PLATTE SELF STORAGE WATER & UTILITY SERVICE PLAN WATER PLAN OVERVIEW AUGUST 2024

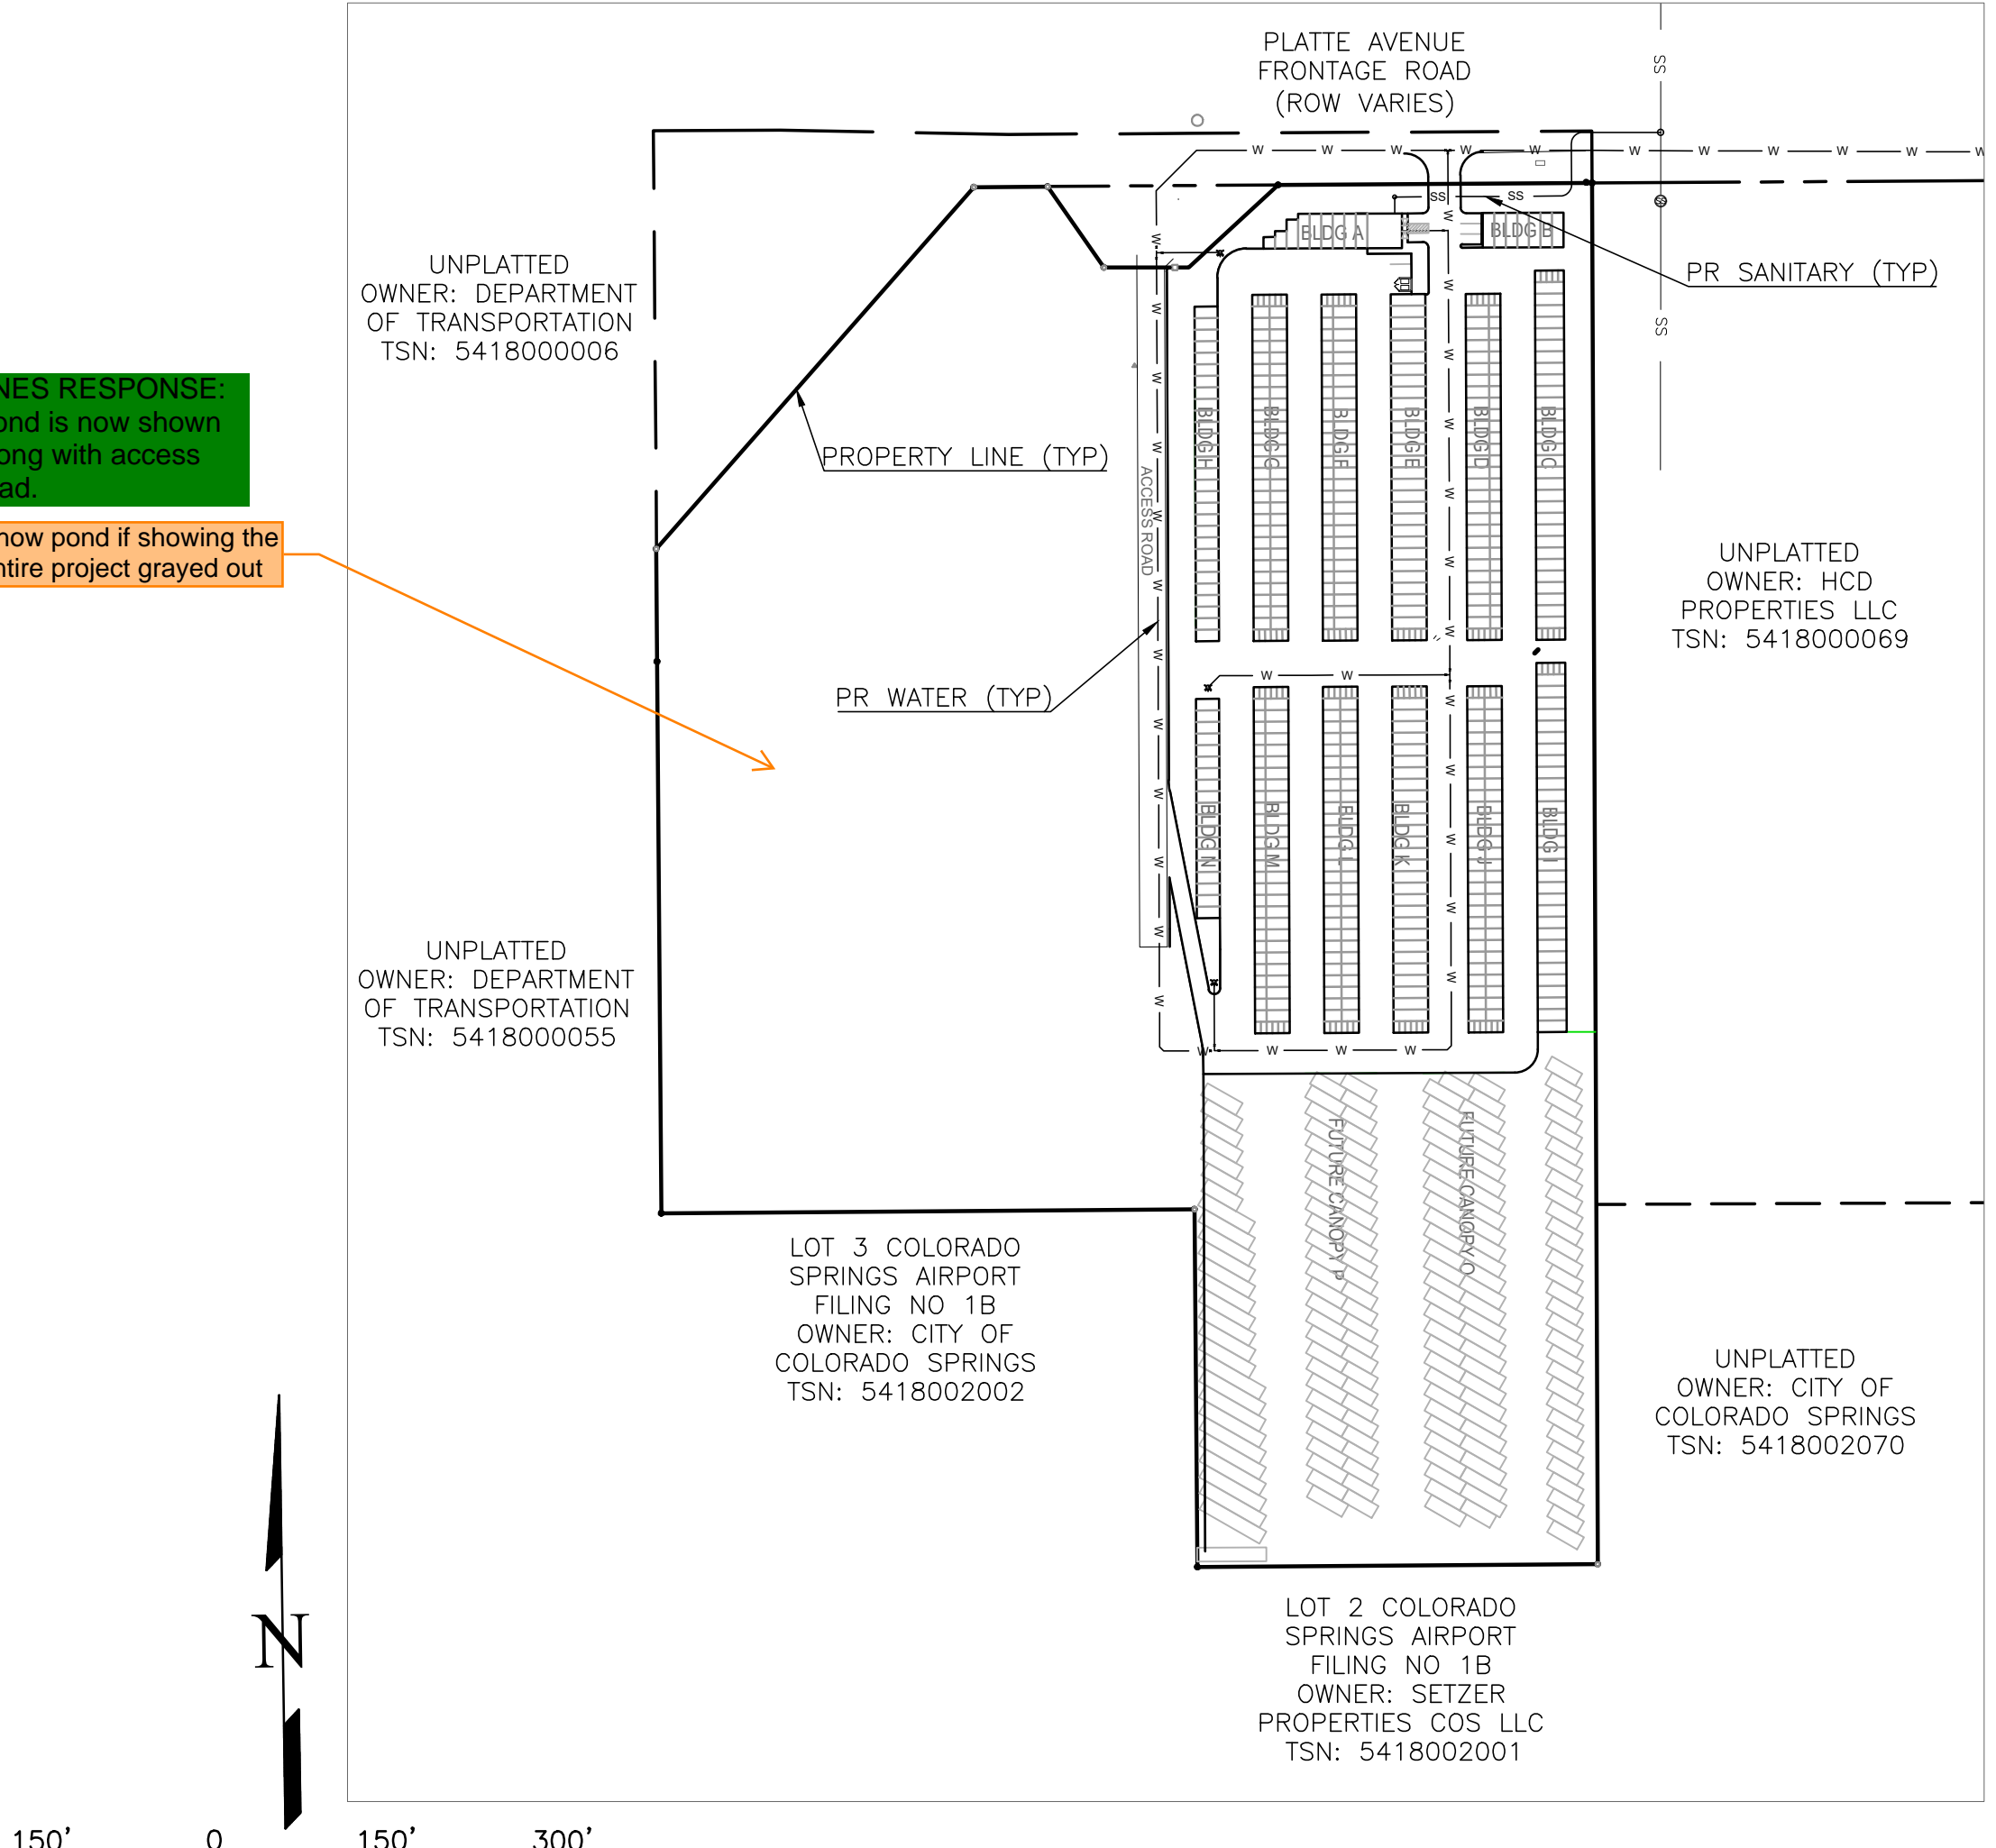
map shows T with cap to the west

note: there's an existing in service 2" cast line that's not on map
